# Rezoning Transportation Analysis

Petition Number: 2020-038

General Location Identifier: Tax ID 20143102

Date	Description
04-22-2020	First Review (EL)
05-19-2020	Second Review (EL)
06-25-2020	Third Review (EL)
08-20-2020	Fourth Review (KP)
11-30-2020	Fifth Review (KP)

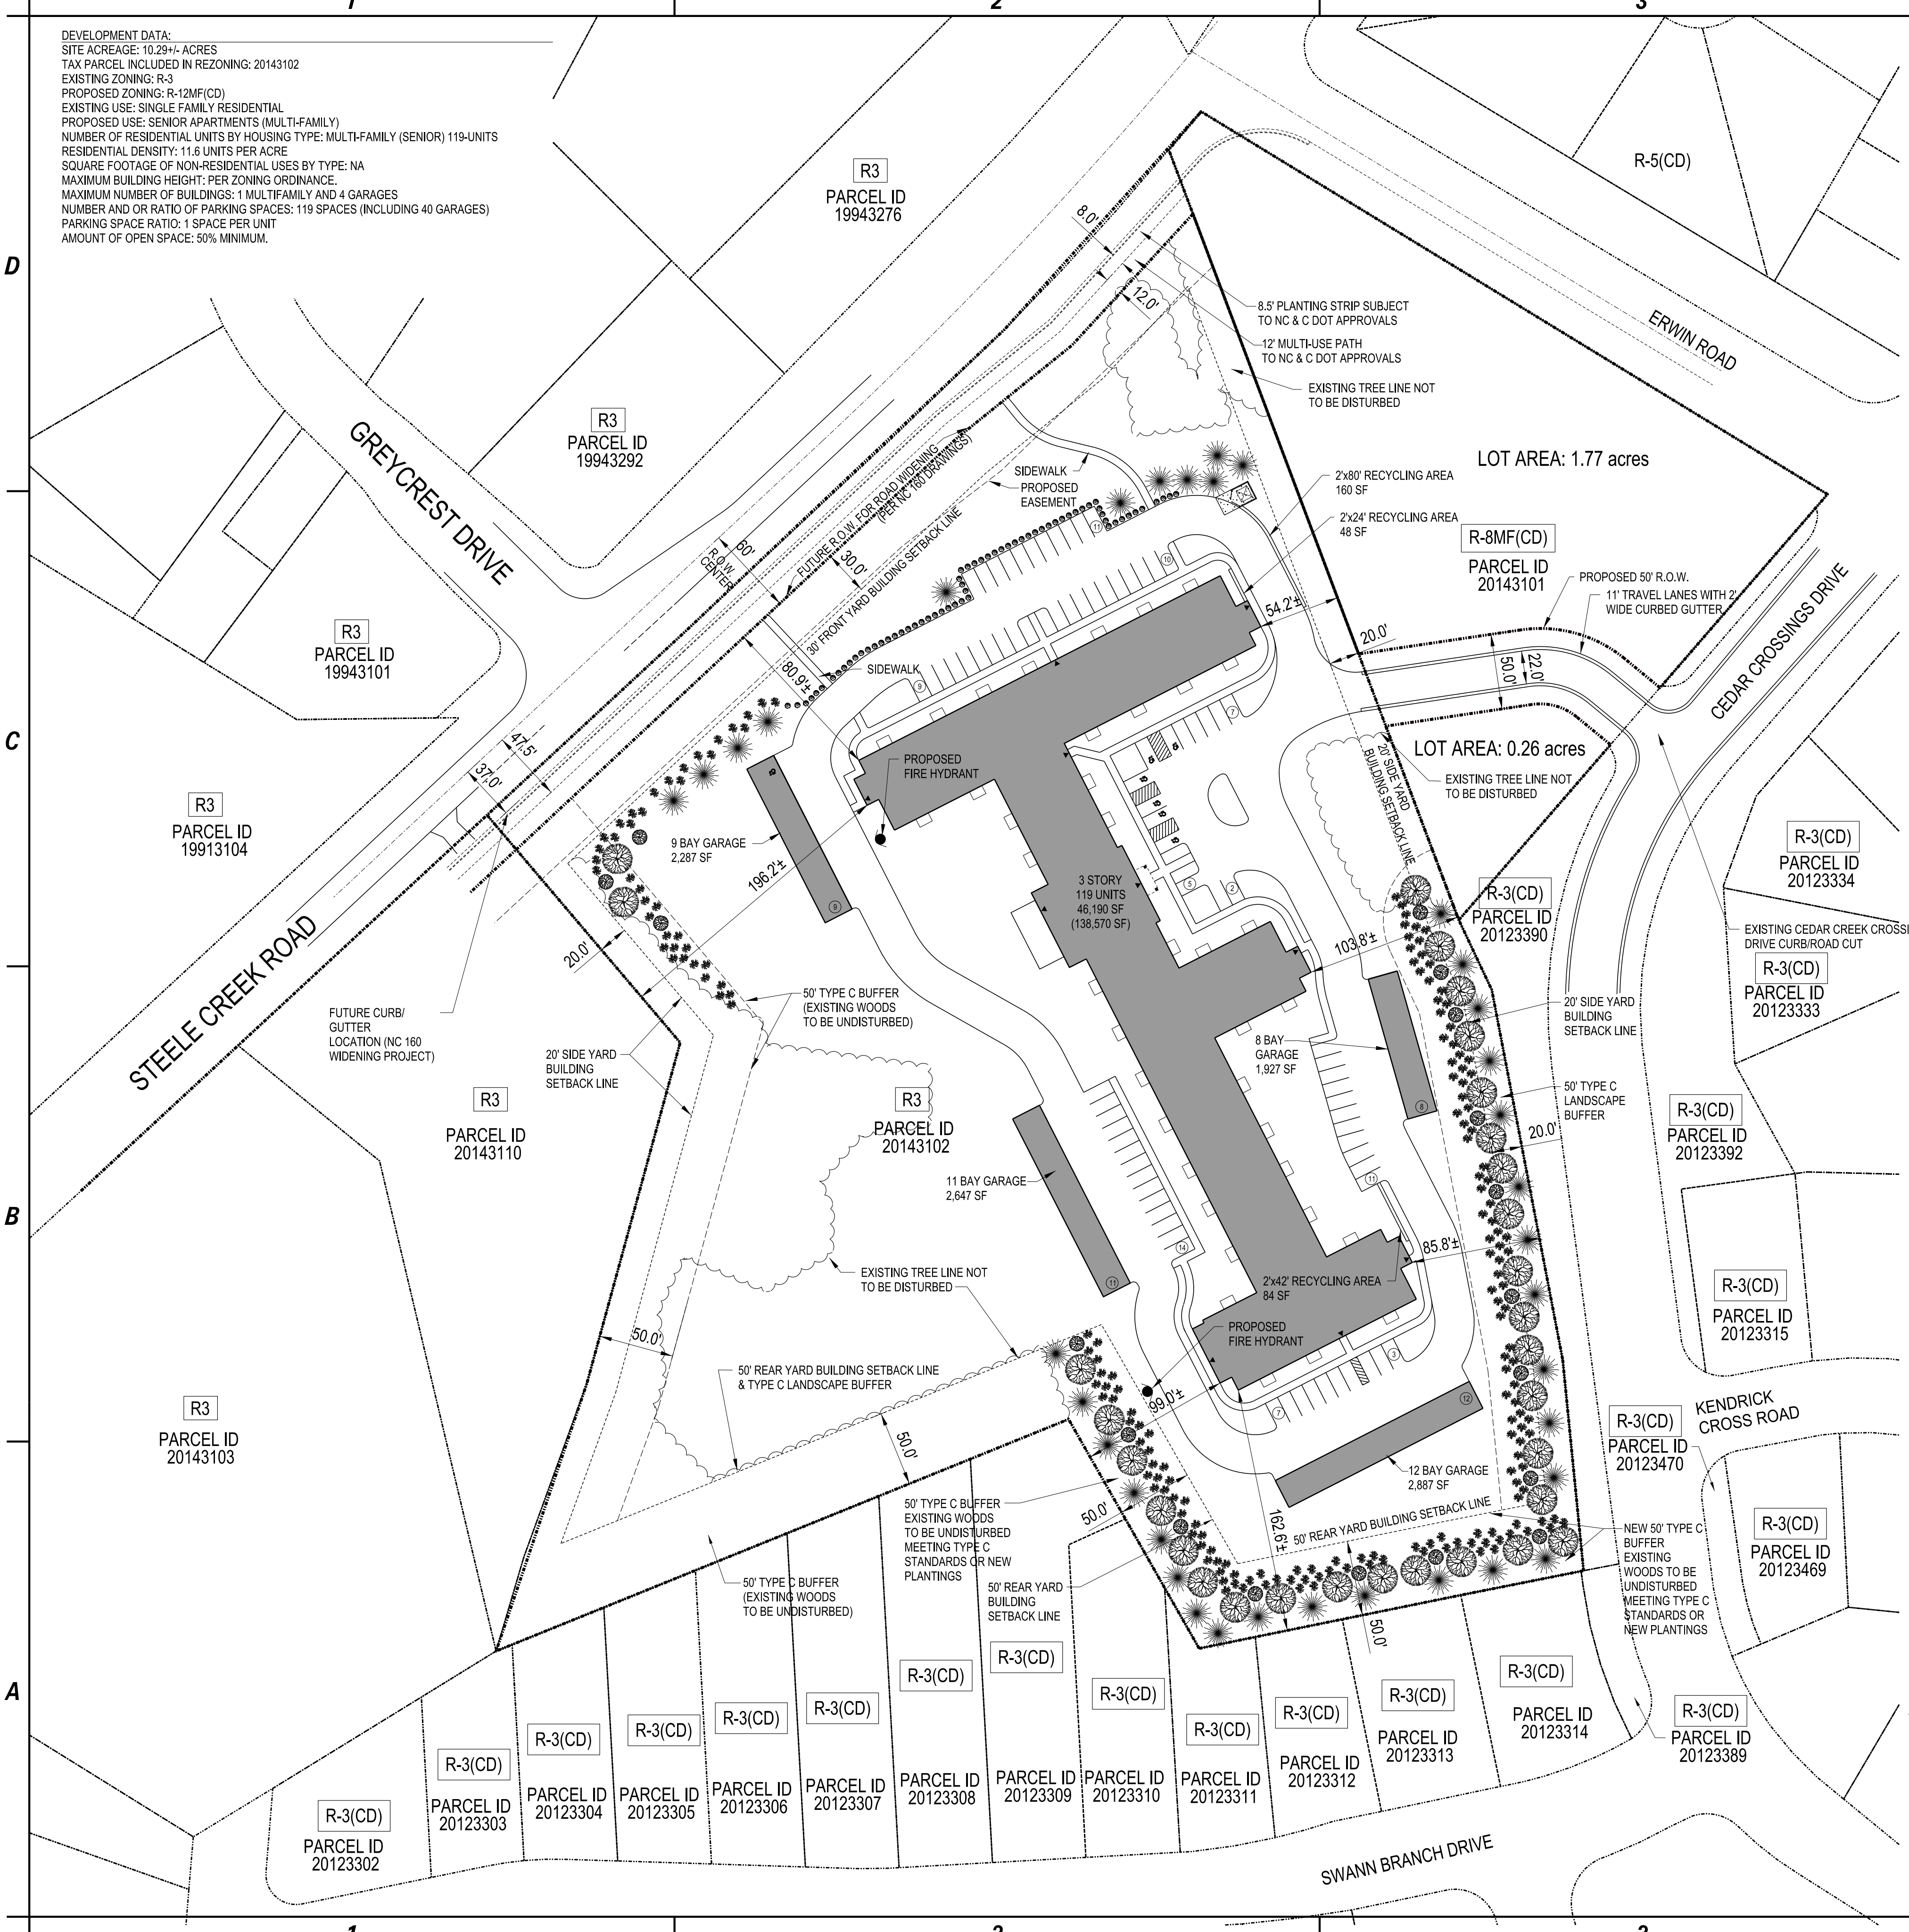
**Updated Comment from 09-14-2020 Site Plan:** It appears this right turn lane is there, however, it is not labeled nor dimensioned.

4. The petitioner should revise the site plan and conditional note(s) to commit to provide a 50-foot driveway stem from the future NC 160 right-of-way line.

a. **New Comment** based on revised site plan dated 4-1-2020): Please refer to the cross section below on the NC 160 project's Map 4 at <https://www.ncdot.gov/news/public-meetings/Pages/U-5766-2019-08-21.aspx>. This resource will provide more guidance to properly revise the driveway stem to provide 50' from the future right-of-way line. The driveway should be perpendicular with the future right-of-way.

7. ~~Rescinded~~ The petitioner should revise the site plan and conditional note(s) to commit to construct an 8-foot planting strip, and 6-foot sidewalk on Cedar Crossing Drive to meet the Subdivision ordinance. The site plan should label and dimension both items from the back of curb and gutter and road centerline.

9. ~~Rescinded~~ The petitioner should revise the site plan and conditional note(s) to include an additional access point to Cedar Crossing Drive, as the Subdivision ordinance require two access points for this type of development. The access should be located opposite of Kendrick Crossing Road.

13. ~~New Comment as a result of the new site plan dated 08/17/2020:~~ The petitioner should update the site plan and conditional notes to show an access easement along the proposed access drive from Cedar Crossing Drive. The petitioner should work with the owner of Parcel 20143101 to obtain this access easement.  
~~Updated Comment from 09-14-2020 Site Plan:~~ Include language in the notes that validation of this easement will be provided to CDOT before final permitting.

**Comment Rescinded as a result of 11-18-2020 Site Plan:** Petitioner stated they will not be making any improvements to NC160.

**Comment Rescinded as a result of 11-18-2020 Site Plan:** Petitioner stated they will not be making any improvements to NC160.
